RE: ENGINEER CERTIFICATION FOR OFFICE & STORAGE FACILITIES @ LOT "D"  
TRACT 4, LANDS OF LOS ANGELES INVESTORS (C17-D17) ENGINEER'S  
CERTIFICATION STATEMENT DATED 6/14/94.

PROJECT TITLE: **Office & Storage Facilities** ZONE ATLAS/DRWNG. FILE #: **C-17/D-17**

RE: REVISED DRAINAGE PLAN FOR OFFICE & STORAGE FACILITIES (C17-D17)  
REVISION DATED 11/29/93.

RE: DRAINAGE PLAN FOR OFFICE & STORAGE FACILITIES (C17-D17)  
ENGINEER'S STAMP DATED 10/25/93.

ASBUILT GRADING & DRAINAGE PLAN

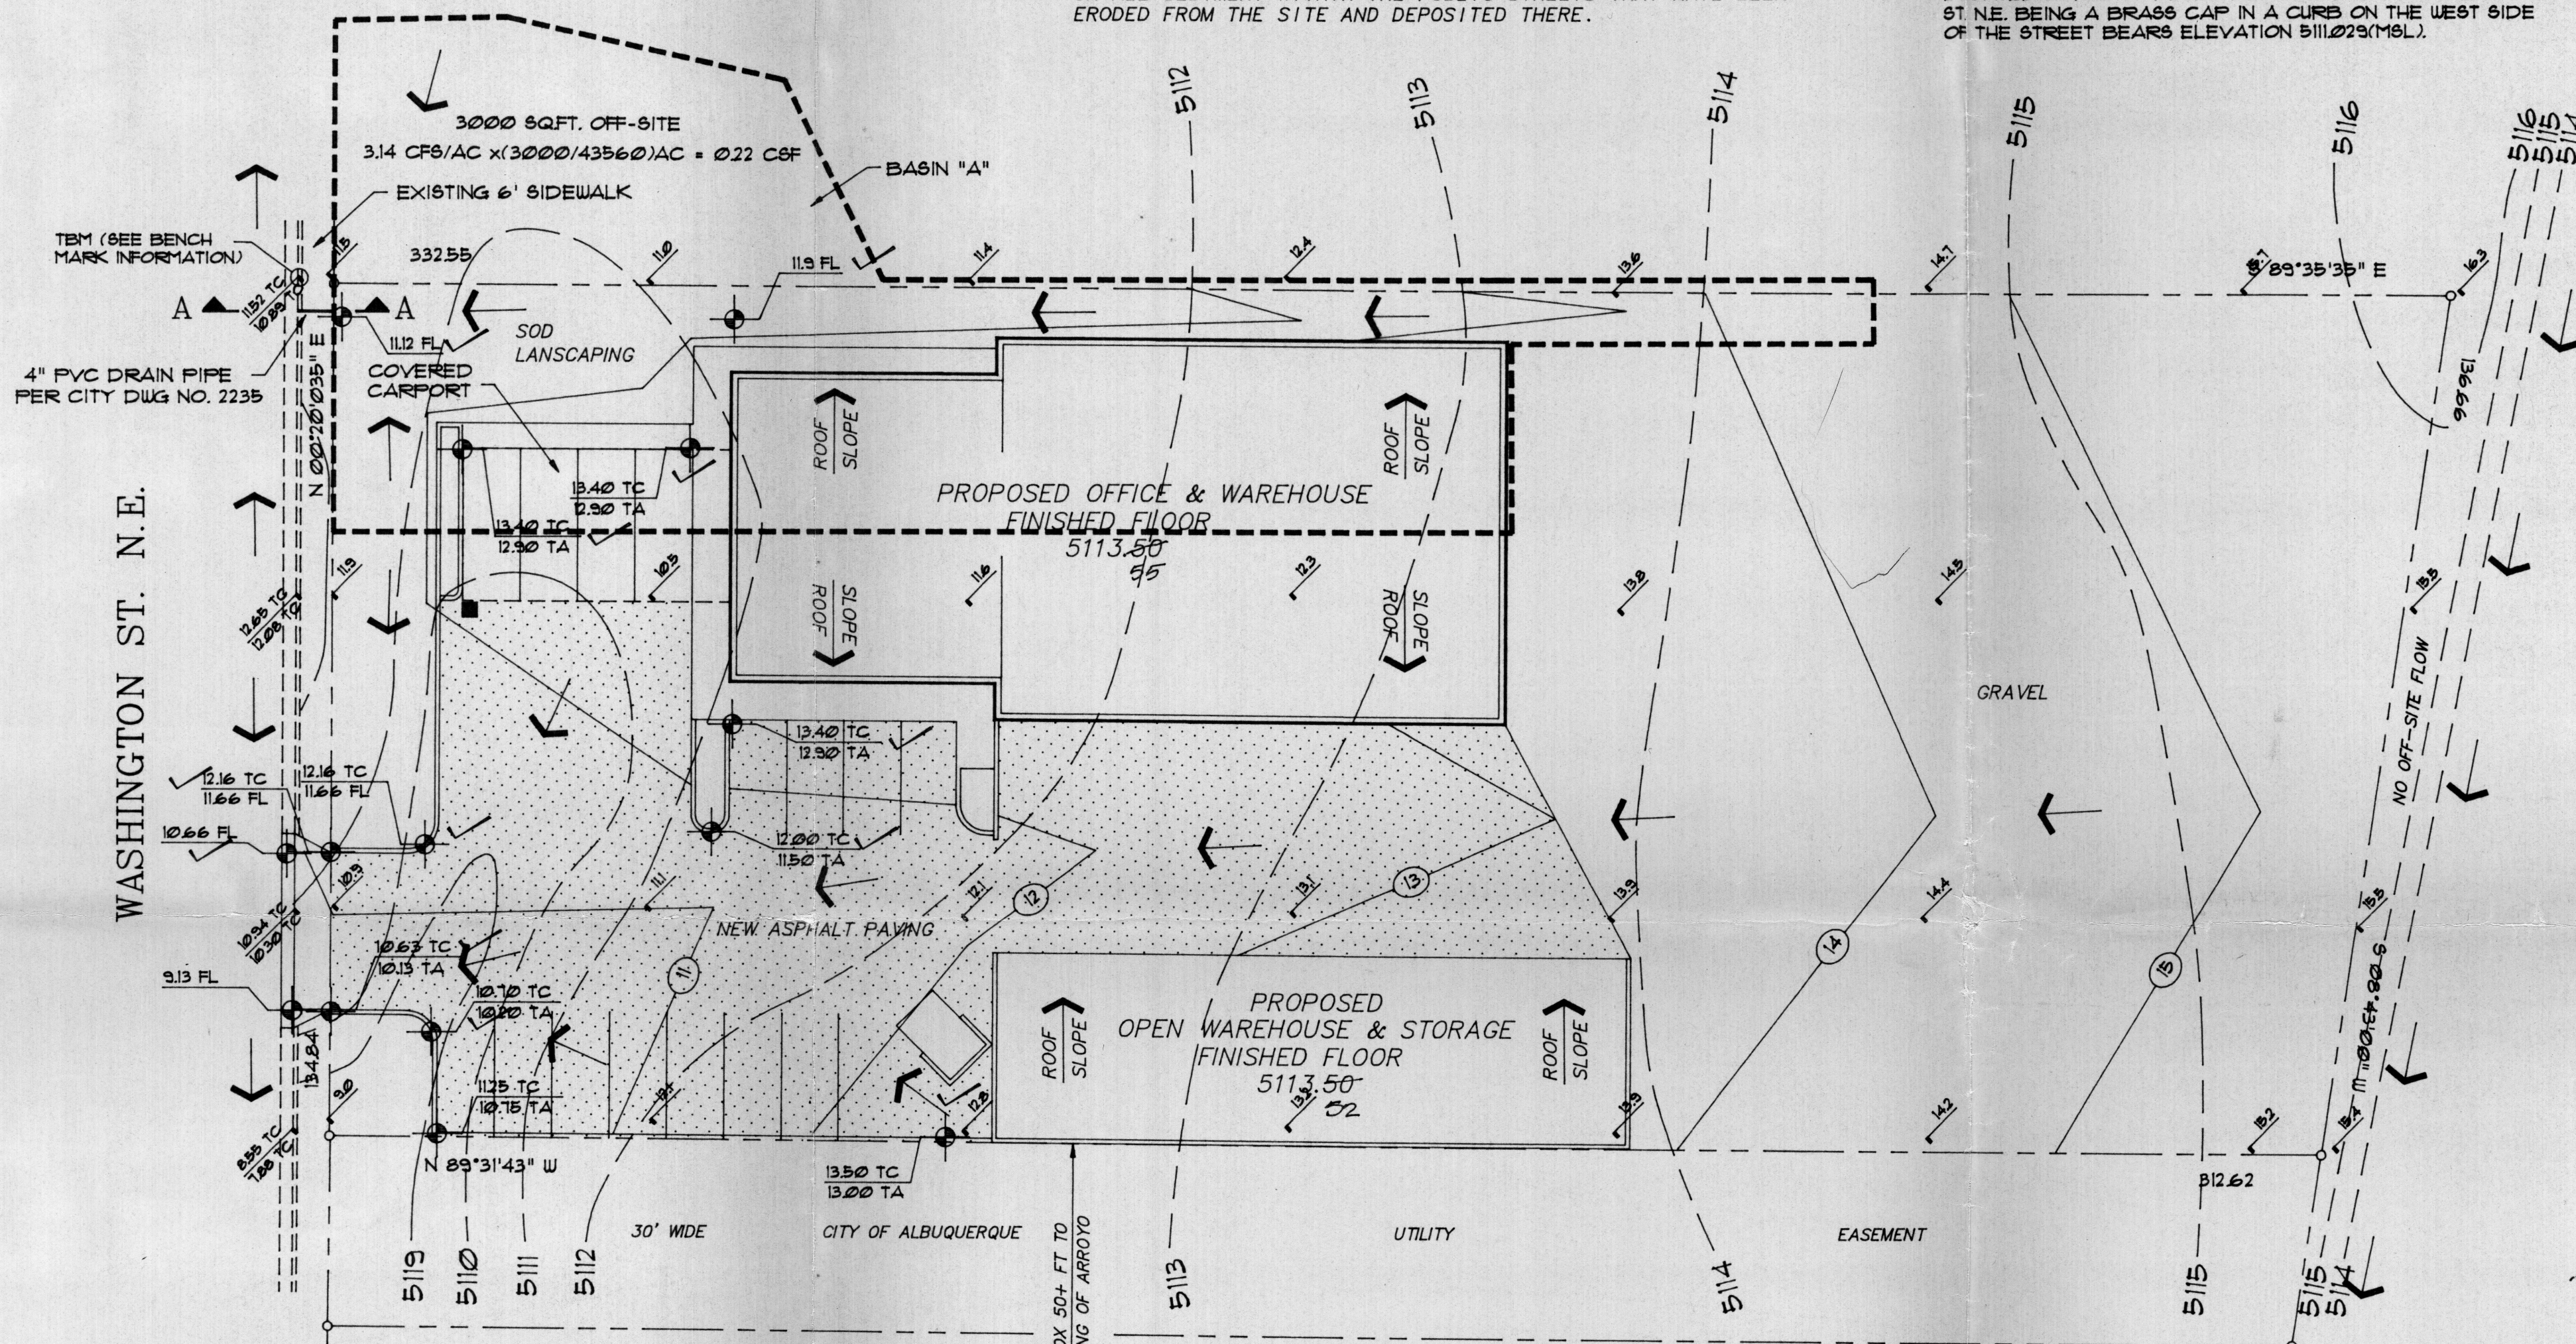
1. ✓ Hydraulics for the proposed 4" pvc pipe. How much basin is draining to the pipe besides the off site flows?
2. ✓ Six notes and sign-off block from the S.O. 19 format. Also, specify the City of Albuquerque Standard Spec. No. for the 4" pvc penetration.
3. ✓ What type of landscaping is proposed? Sediment control must take place prior to run-off entering the 4" pvc pipe.
4. ✓ You may want to gutter the complete roof area towards the asphalt.
